DEVELOPMENT FACILITATIVE TEAM (DFT)

Code Enforcement Comments

[PR-2023-009591](#)

SD-2023-00214 – PRELIMINARY/FINAL PLAT

EXHIBIT
SITE PARKING

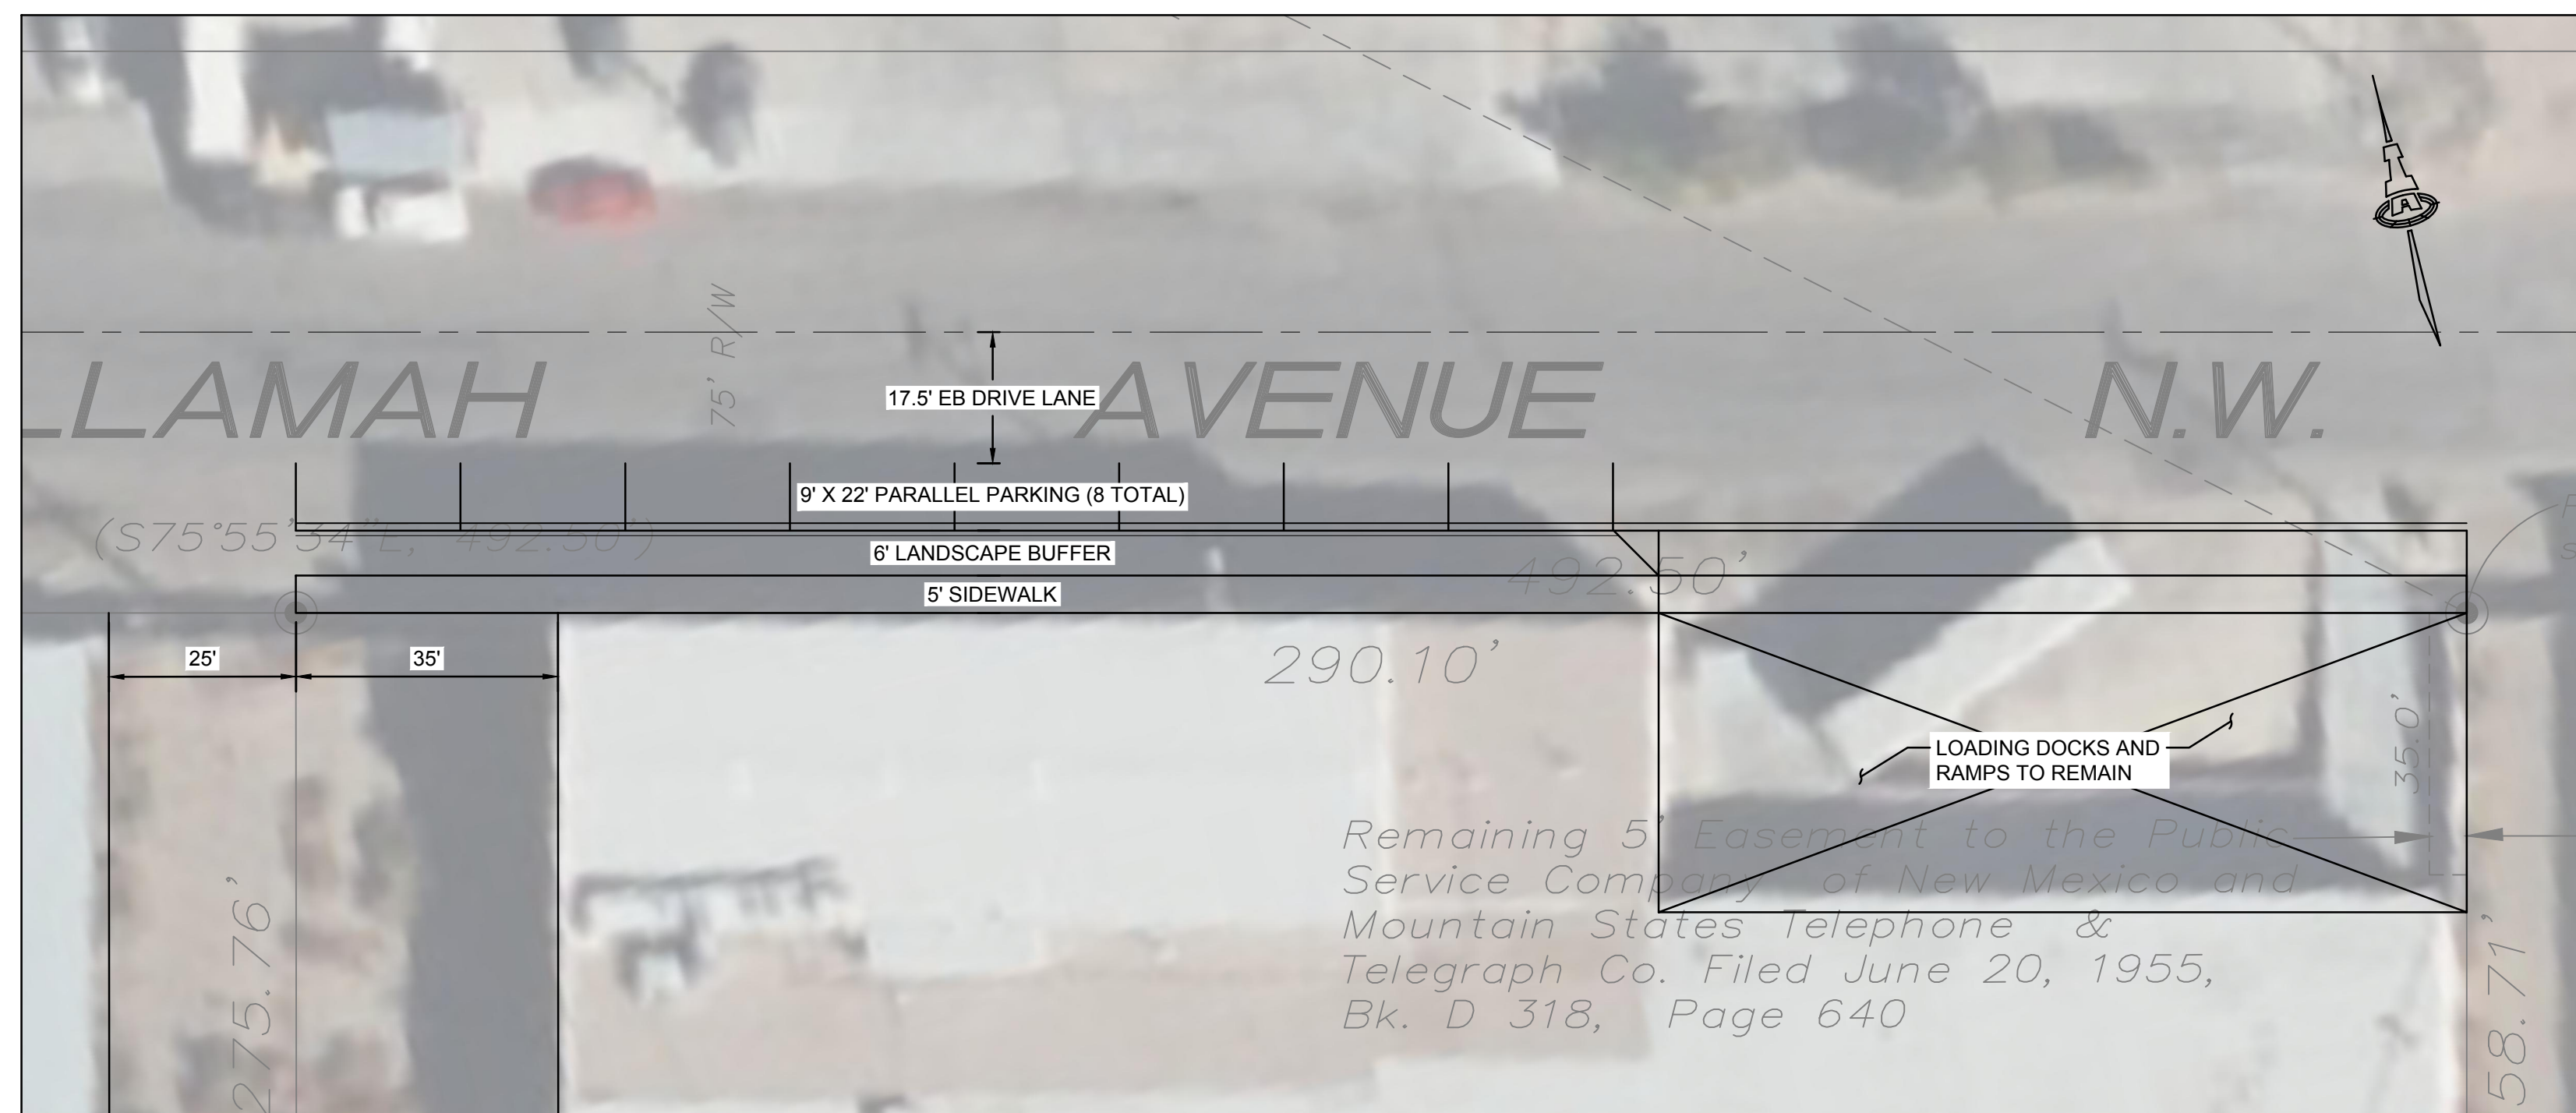
1. Please confirm that re-plat is not affecting current business use parking requirements on either property.
2. If there are no conflicts with parking requirements, Code Enforcement has no objections to the re-plat. However, we do have a few comments regarding future development:
